# SUBMISSIONS REPORT

SSDA-10448 Mod 2  
Aspect Industrial Estate

Prepared for  
**MIRVAC**  
23 September 2022

Drawing Name:  
Tree Canopy Plan

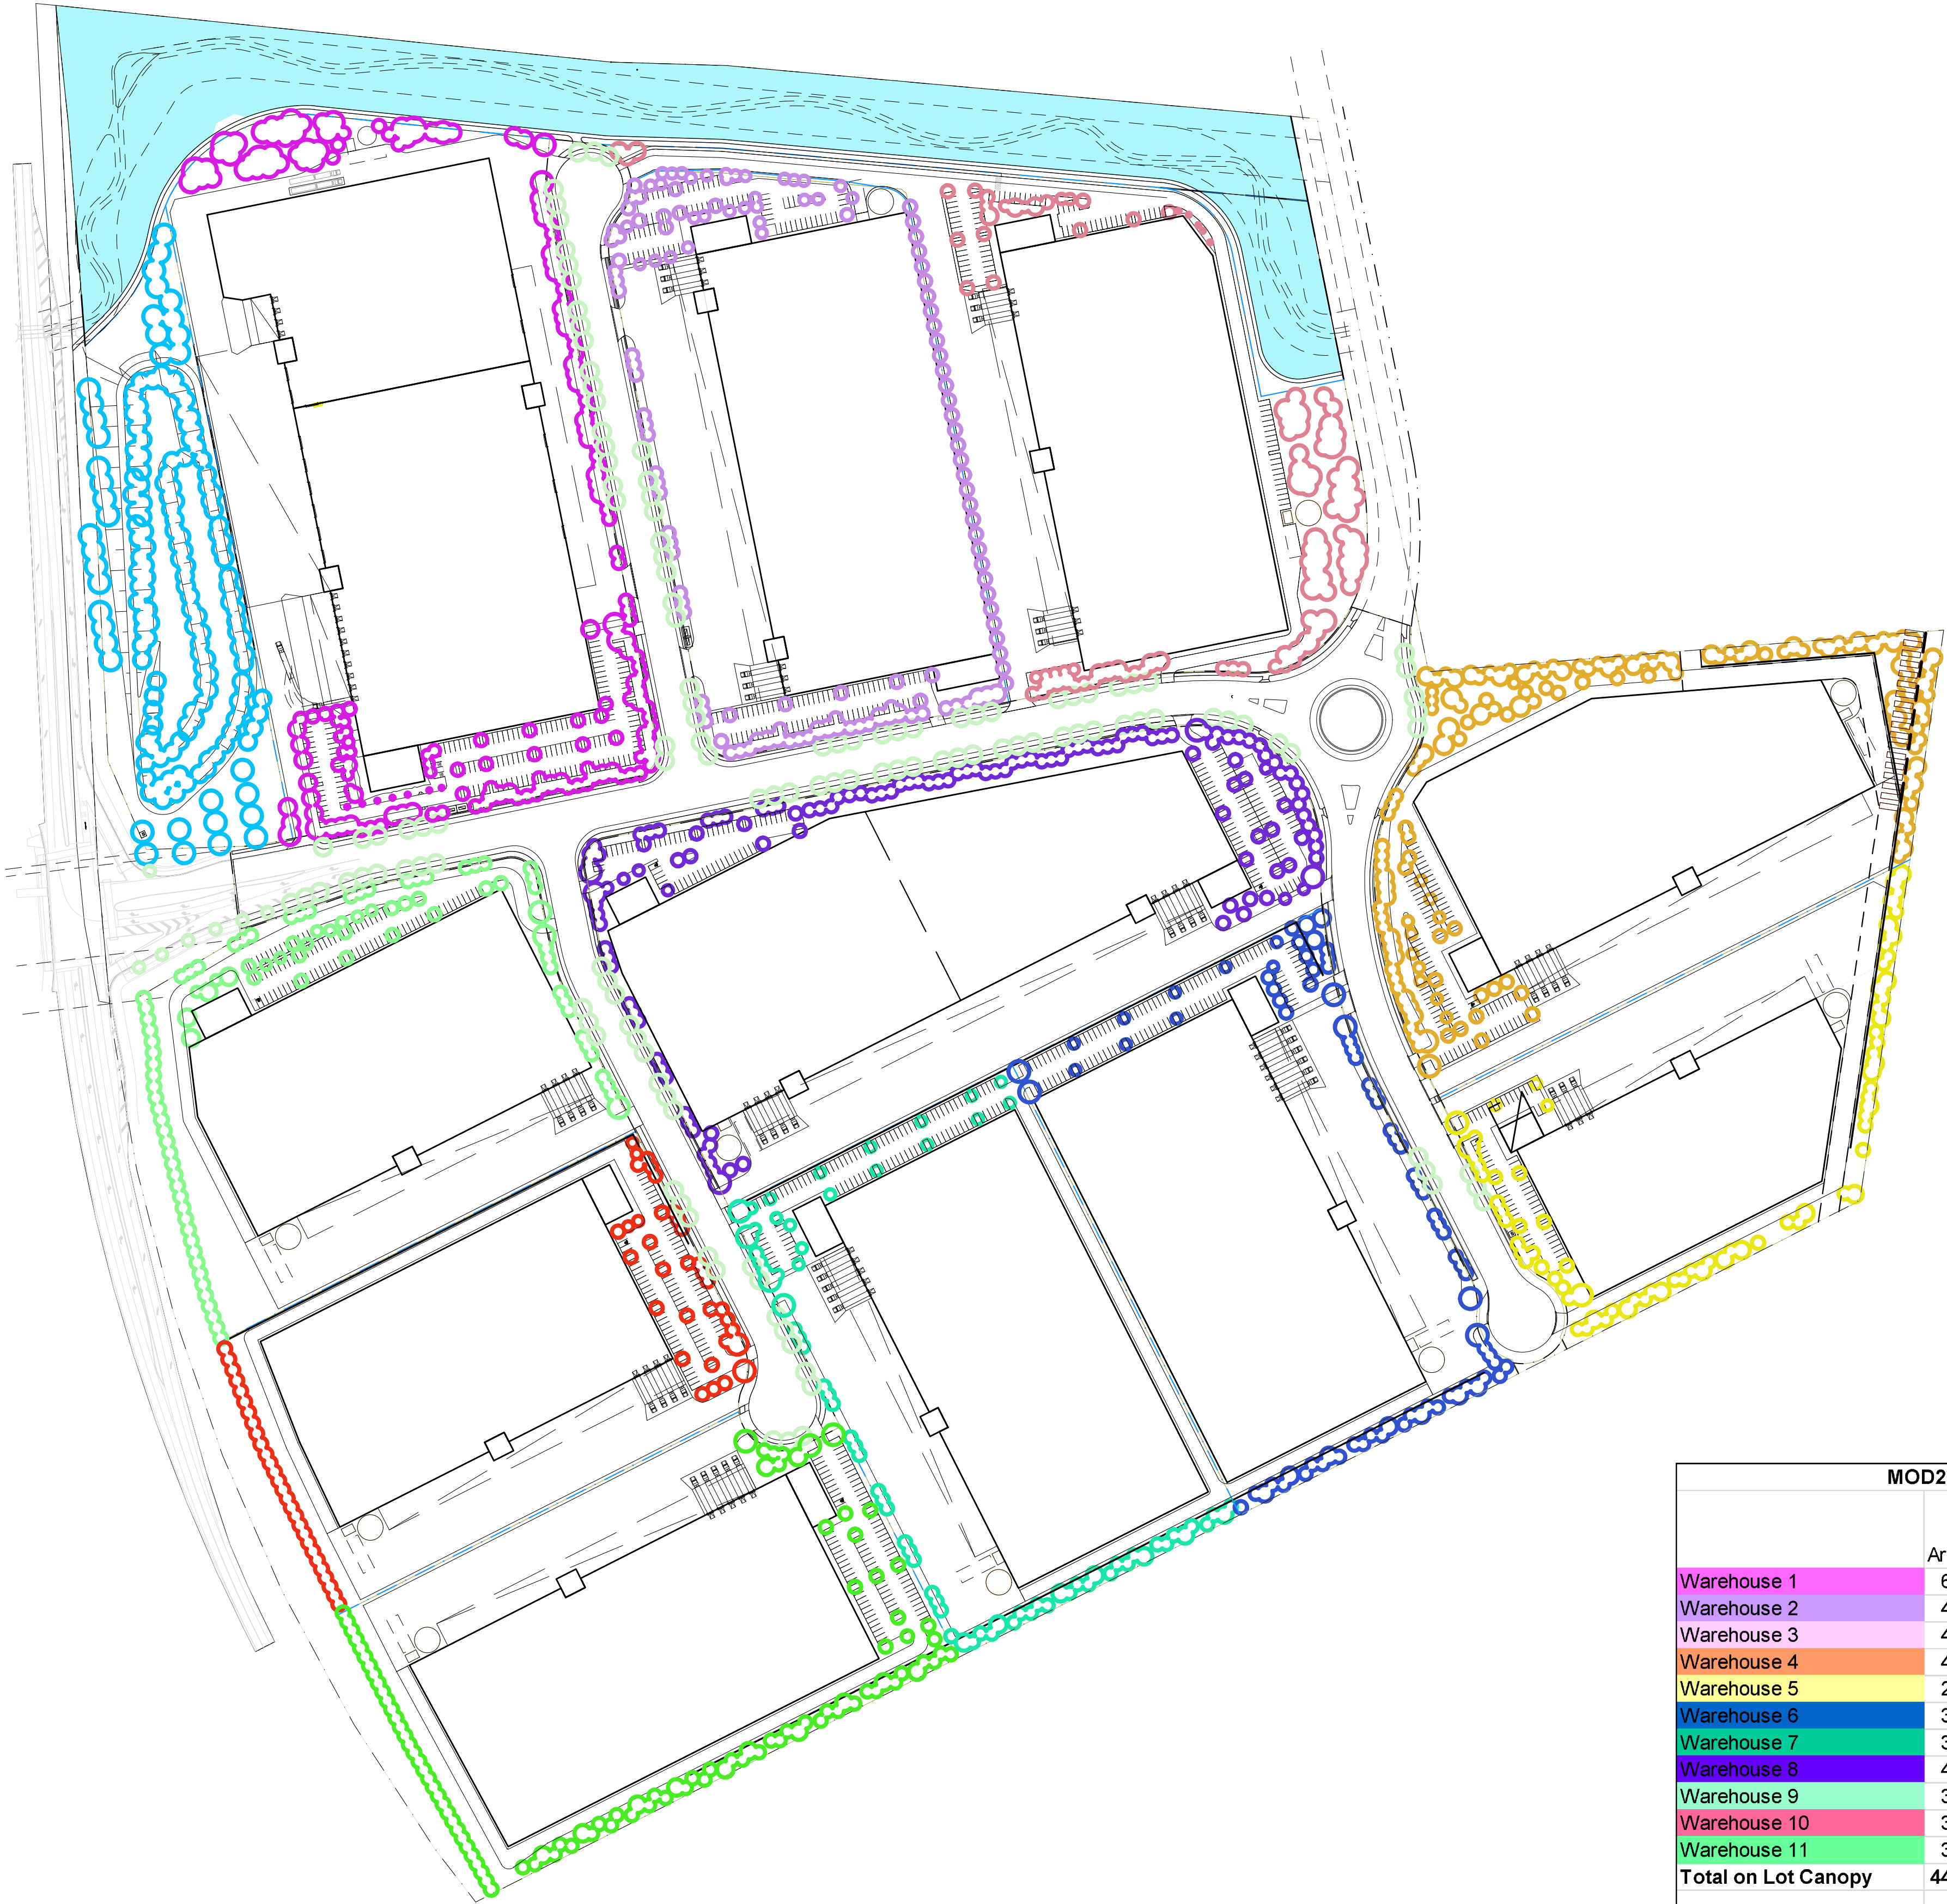
Summary of Issue Raised	Response	Supporting Document
<p>(d) The landscape master plans accompanying the application propose 18 x Spotted Gums being a mature height of 30m with a canopy spread of 8m.</p> <p>Spotted Gums shown on the Tree Planting Masterplan S1-1 001 Rev A are not indicated on the Lot 1 on-lot works landscape plans (refer S1-1_101 through 103 revision P and Figures below).</p> <p>Previously provided section through this area have been removed from the civil and landscape sets.</p> <div style="display: flex; justify-content: space-around; align-items: flex-end;"> <div style="text-align: center;">  <p><b>Figure 7:</b> Applicant's Landscape plan – Warehouse 1 – 05 refers to Spotted Gums</p> </div> <div style="text-align: center;">  <p><b>Figure 8:</b> Applicant's On-Lot Works Landscape plan – Warehouse 1 – Excerpt.</p> </div> </div>	<p>The plan and figure referenced in this commentary is outdated. This plan submitted to Penrith City Council is outdated and included in the application package by mistake.</p>	<p>N/A</p>

Summary of Issue Raised	Response	Supporting Document															
<p><b>Figure 9:</b> Civil plans indicating no space for canopy tree planting (refer 18-596-C2143 issue 1)</p> 																	
<p>Notwithstanding the above, trees are not achievable in the selected location upon review of the sections and owing to the location of the palisade fencing, the retaining wall, and the super awning above.</p>	<p>The refined landscape plans and masterplan has been prepared to be consistent with the latest architectural plans and civil drawings.</p>	<p><b>Appendix C</b></p>															
<p>Council strongly recommends that DPE require that the Aspect precinct achieve compliance with the minimum 10% canopy tree targets as is required under the Mamre Road Precinct DCP.</p> <p>Canopy trees previously approved in the Estate are significantly reduced by the amended plans which is not supported by Council. The resultant presentation of Warehouse 1 to Mamre Road is to be addressed and improved. The warehouse footprint is to be reduced to enable the provision of canopy trees, shrubs and along this elevation.</p>	<p>The refined landscape plans identify the updated Lot 1, 2, and 3 tree canopy coverage as part of MOD 2 compared to the approved SSD. The updated landscape plans generally accommodate an increase in the on-lot canopy coverage and the overall estate will continue to achieve compliance with the Mamre Road Precinct DCP.</p>

SSDA	MOD2	WH1	4%	10%	WH2	4%	9%	WH3	9%	9%	Total Site	13%	15%	<p><b>Appendix D</b></p>
	SSDA	MOD2															
WH1	4%	10%															
WH2	4%	9%															
WH3	9%	9%															
Total Site	13%	15%

WAREHOUSE 3	
Site Area	42,755 m <sup>2</sup>
Offices	700 m <sup>2</sup>
Warehouse	20,735 m <sup>2</sup>
Dock Office	100 m <sup>2</sup>
Total GFA	21,535 m <sup>2</sup>
Carpark Provided	89

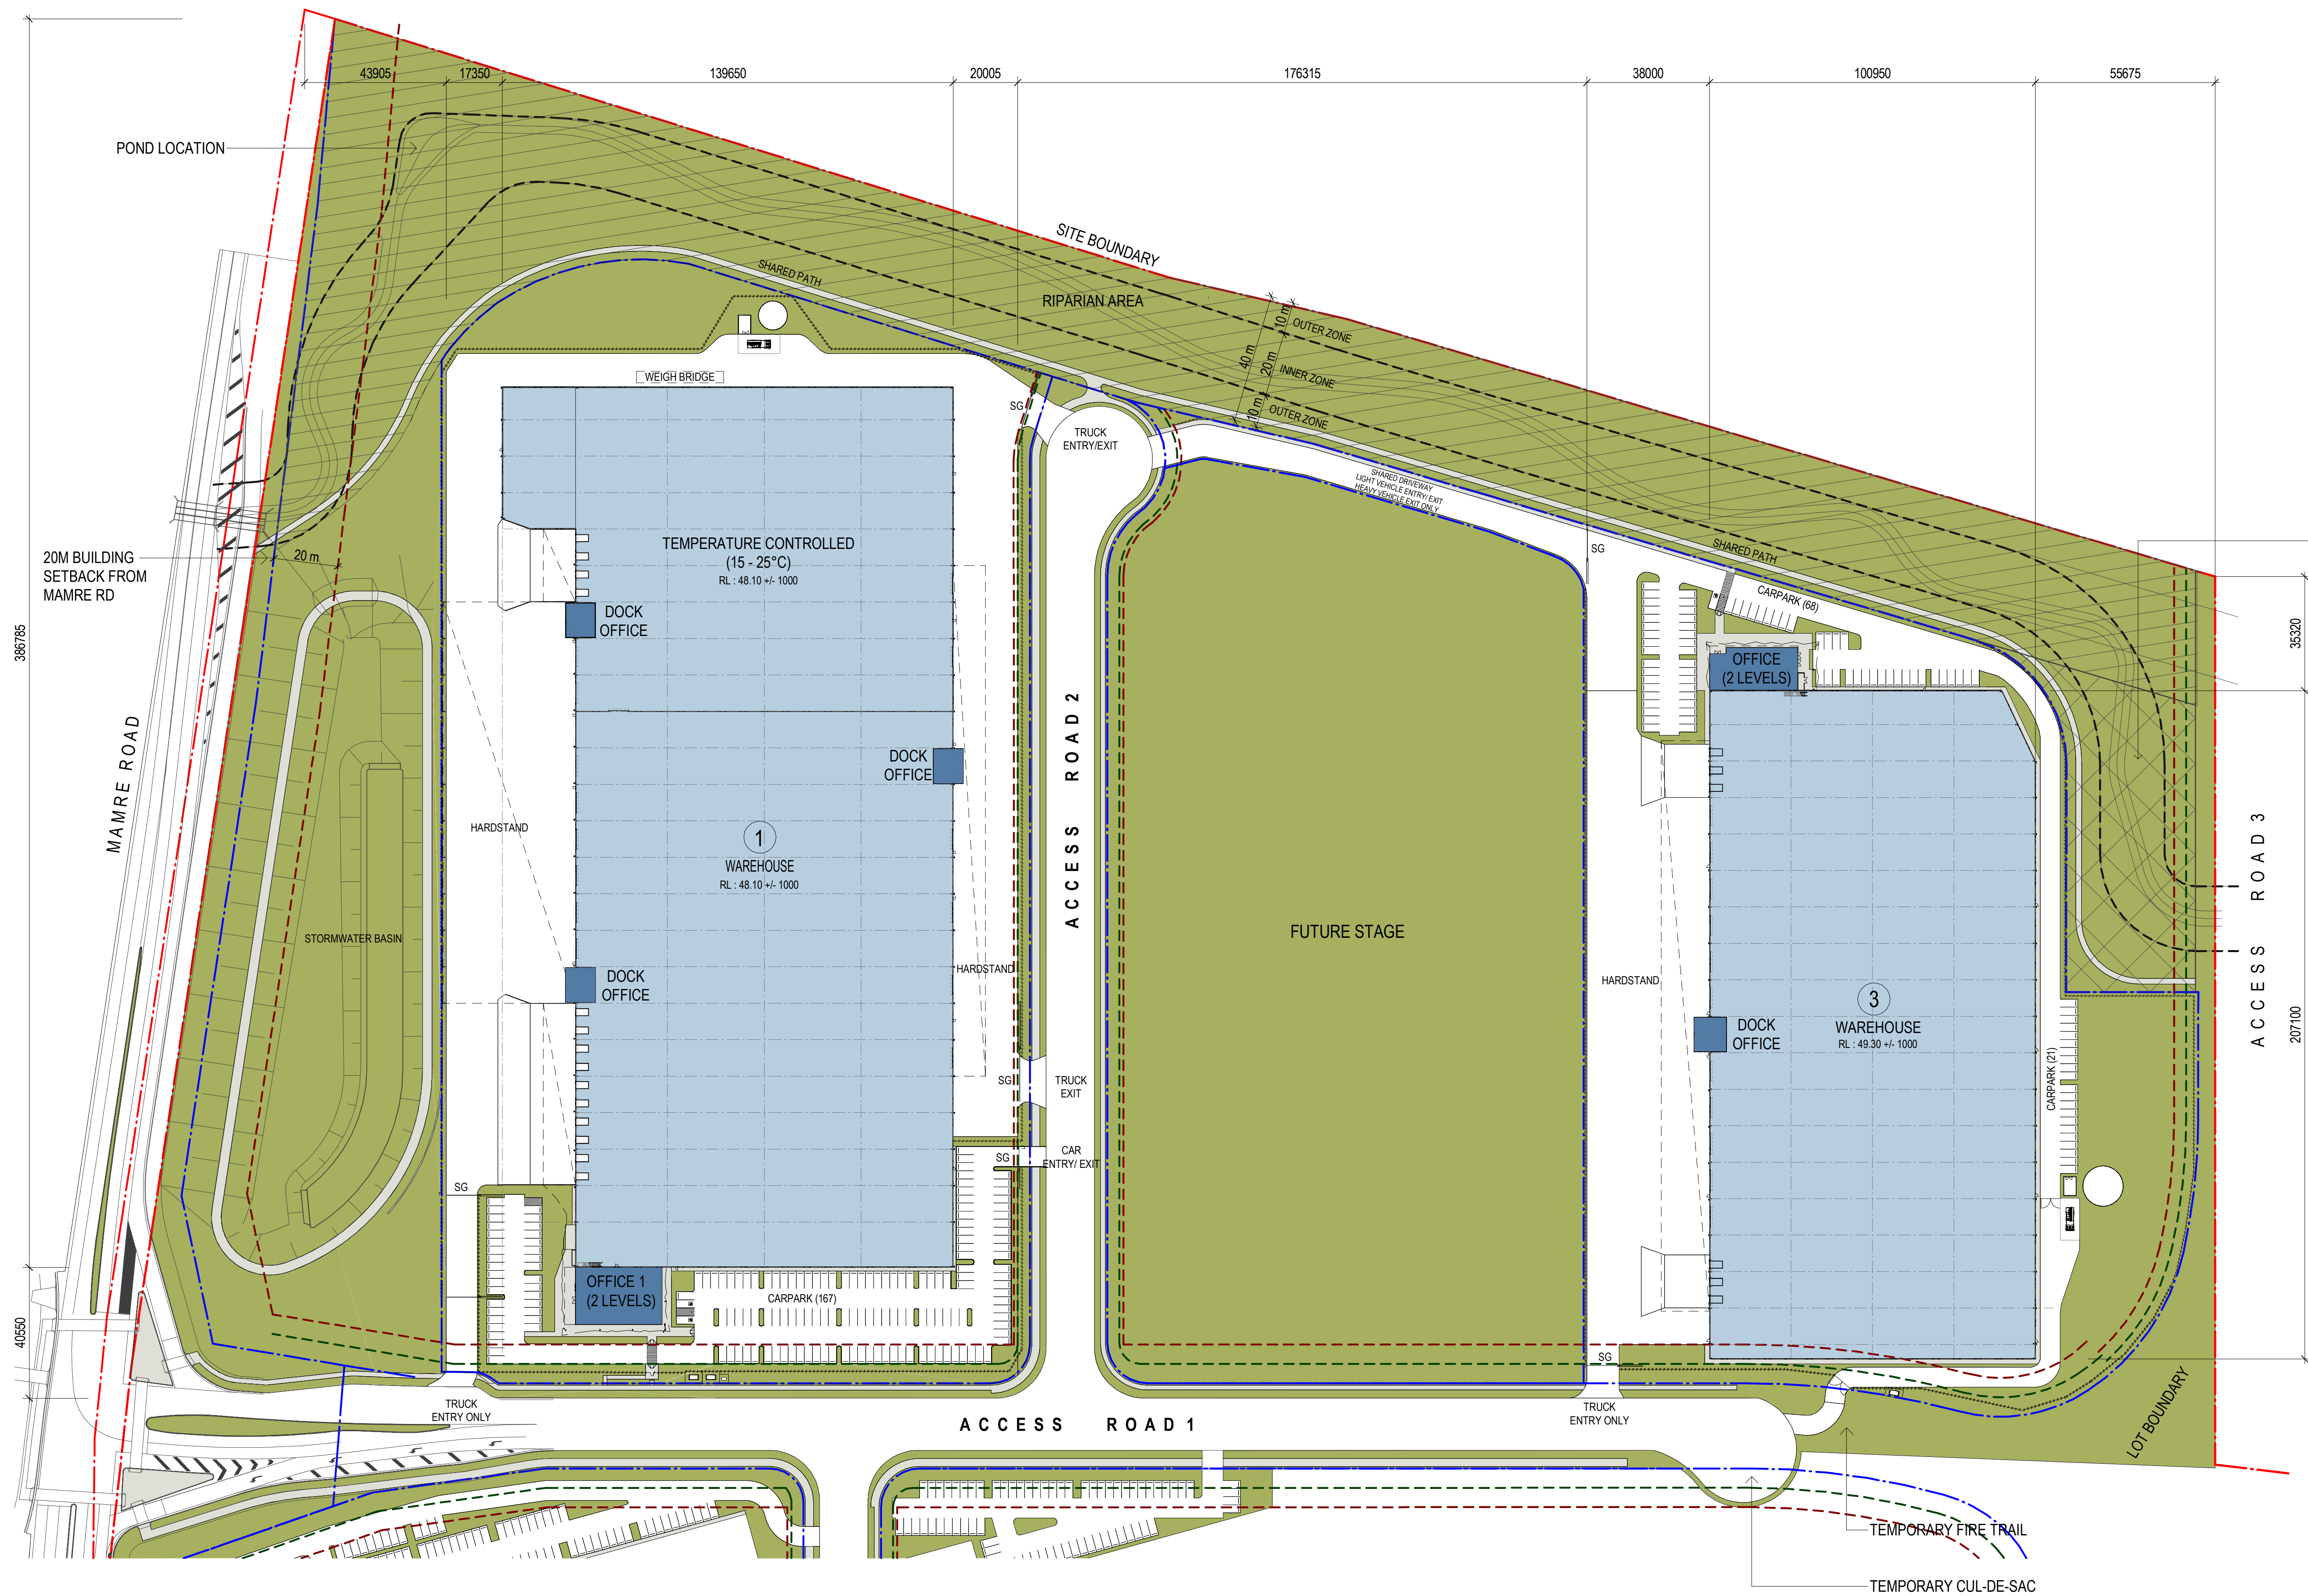
No safe pedestrian pathway is provided for staff and visitors along the northern private driveway for Warehouse 3.	As per the refined drawings, a pedestrian pathway has been provided for access from the crossover on Access Road 02 to Warehouse 3.	Appendix A
It is noted that larger floor areas for warehouses can be gained by spreading car parking out along access roads around the periphery of the warehouses. This is a	As detailed in the commentary above and in <b>Section 2</b> of this report, the refined plans	Appendix A

<p>It is reiterated that heavy vehicles be fully separated from staff and visitor vehicles.</p>	<p>The refined plans demonstrate that there will be distinct, separate travel paths for heavy and light vehicles to Warehouse 3. The refined lot boundaries and driveway alignment facilitates a swept path analysis on the master plan drawing that confirms that trucks will not cross the into oncoming cars entering the carpark.</p> <p>The updated Traffic Impact Assessment (TIA) report includes a swept path assessment which demonstrates the driveway design will facilitate separated paths of travel.</p>	<p><b>Appendix A and H</b></p>
<p><b>Landscaping</b></p>		
<p>Council has previously raised that landscaping along the Mamre Road frontage and along the frontage to Warehouse 1 is unachievable when reviewed against the civil sections. The EIS does not adequately respond to this matter.</p>	<p>The refined landscape plans and masterplan have been prepared to be consistent with the latest architectural plans and civil drawings.</p>	<p><b>Appendix C</b></p>

Summary of Issue Raised	Response	Supporting Document
	<p>AS2890.2:2018 and results in more efficient and safe operation of loading areas.</p> <p>Therefore, the proposed access arrangements remain the preferred option.</p>	
<p>The proposed internal circulation roadways for Warehouse 3 shared between passenger vehicles accessing the carpark and heavy vehicles accessing the hardstand this is not supported on safety grounds.</p>	<p>The refined plans demonstrate that there will be distinct, separate travel paths for heavy and light vehicles to Warehouse 3. This includes inbound and outbound light vehicle movements from Access Road 2, with outbound heavy vehicle movements only form the hardstand to Access Road 2.</p> <p>The refined lot boundaries and driveway alignment facilitates a swept path analysis on the master plan drawing that confirms that trucks will not cross the into oncoming cars entering the carpark.</p> <p>The updated TIA report includes a swept path assessment which demonstrates the driveway design will facilitate separated paths of travel.</p>	<p><b>Appendix A and H</b></p>
